Consultee Comments for Application 2025/92161

Application Number: 2025/92161

Address: land adj, 17 Whitehall Road West, Birkenshaw, BD11 2LS

Proposal: Discharge of details reserved by conditions 4-8 (intrusive investigations), 11 (Remediation Strategy and Verification Report), 12 (CEMP), 13 (noise), 14 (Arboricultural Method Statement), 15 (CMP), 16 (highway), 17 (visibility), 18 (Safety Audit), 19 (estate streets), 20 (waste collection), 21 (surface water attenuation), 24 (bin storage), 25 (bicycle storage), 26 (drainage), 28 (drainage), 29 (CEMP: Biodiversity),-30 (landscape), 34 (solar panel array), 35 (materials), 38 (boundary treatments) on previous permission 2024/92281 for erection of 23 dwellings

Date: 20.07.25	PROJECT Whitwell rd, Birmingham
Scale & AE: 1:50	Drawing Number: 2400-002-001
Drawn By: CJ	Revision: -
	Drawing Title: TYPICAL CYCLE STORE DETAIL

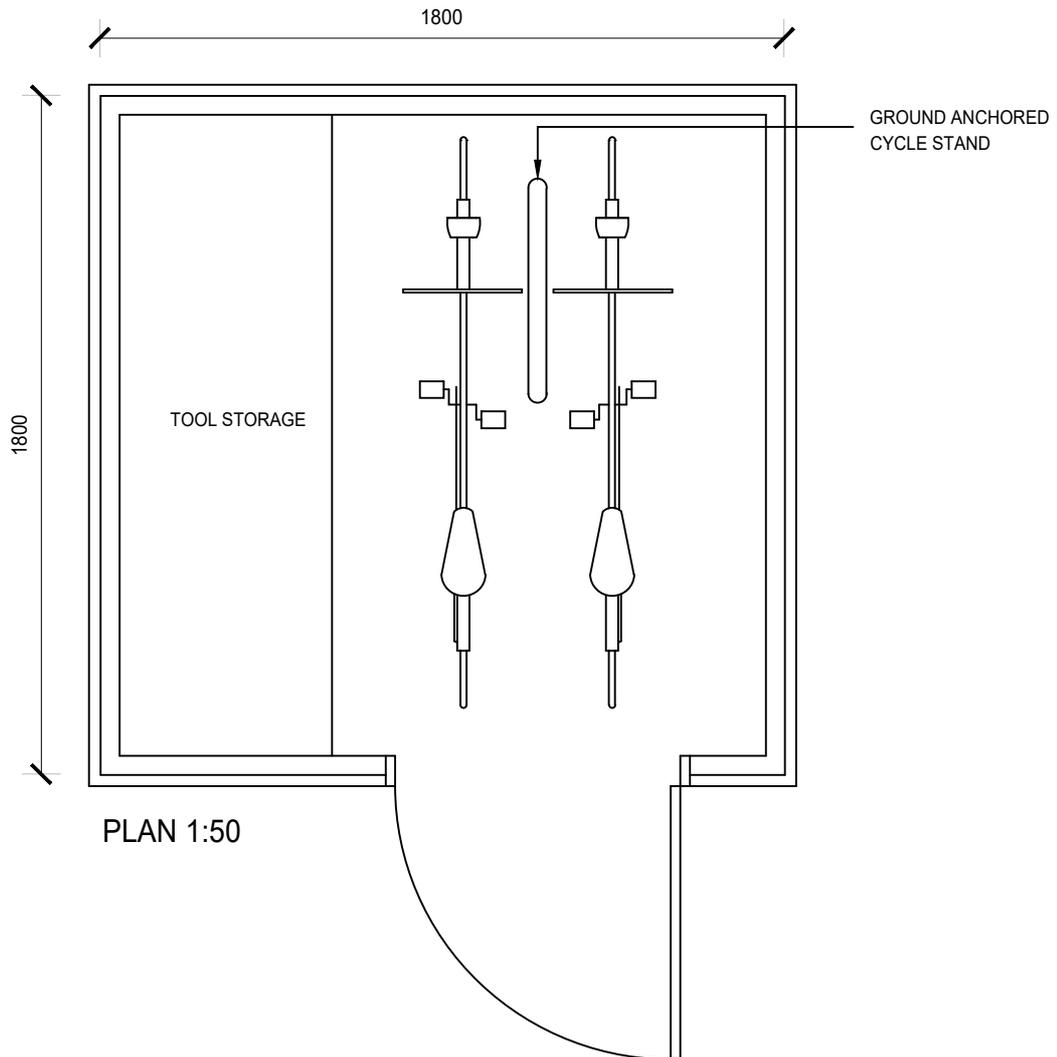
- Typical Cycle Store Detail, Drawing Number 2306-002-007.

Condition discharged.
